**THE MILL, HIGH STREET, MOULTON, SPALDING, PE12 6QB
Application Nos H13-0459-25 & H13-0458-25**

The proposal seeks to install solar panels at Moulton Mill, to the south elevation of the former granary building which is attached to the east of the windmill. Moulton Mill is located within Moulton Conservation Area.

Front Elevation (SE)
Scale: 1:100

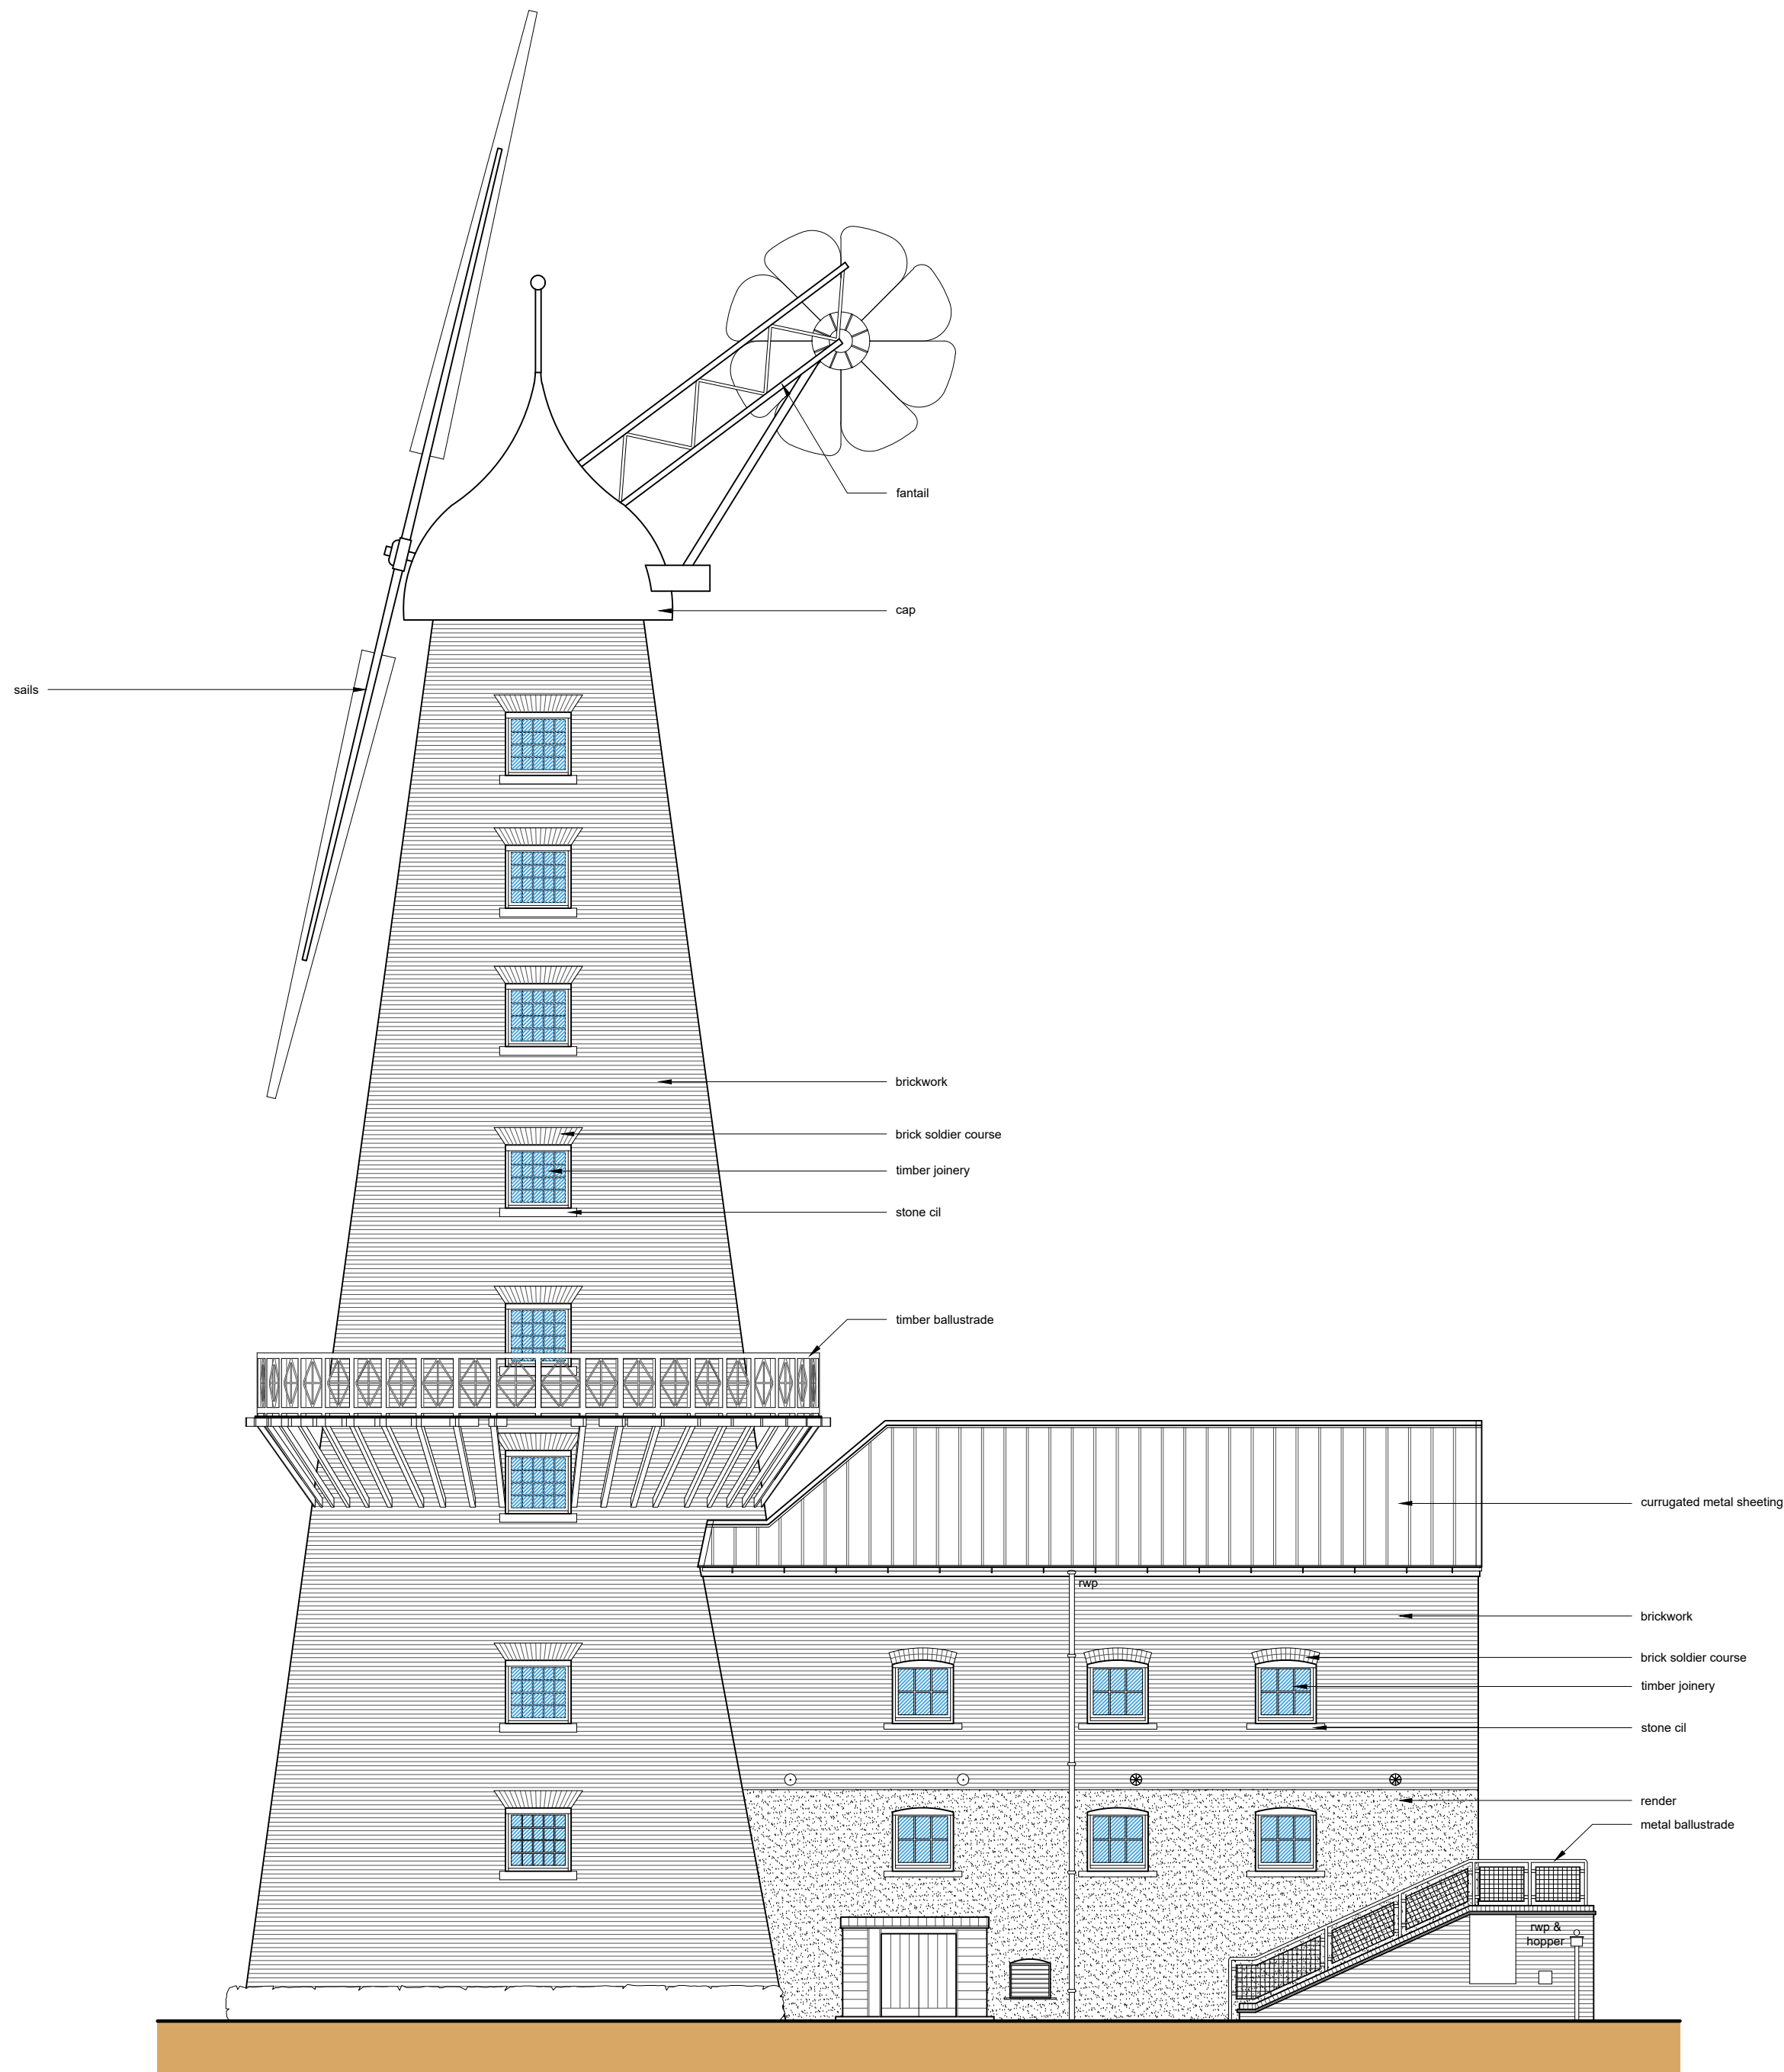
The installation of photovoltaics in this prominent location would be highly visible in views of the Windmill from the south. They would become a conspicuous element of the south elevation and would cause harm to the significance of the building through

erosion of its historic character. This visual impact would be exacerbated by the pitch of the south roof slope.

The harm would be caused by the starkly modern character of the proposed photovoltaics viewed in juxtaposition to the historic character of the Grade I listed building, and the consequent effect on the architectural and historical character of the mill.

Historic England is concerned that the proposed location of the photovoltaics on the south roof slope would look visually obtrusive and harmfully impact the significance of the Grade I listed mill and that of the Moulton Conservation Area.

We encourage the consideration of alternative ways to generate renewable energy, such as ground-mounted solar collectors, which would be less harmful to the significance of the Grade I listed mill.
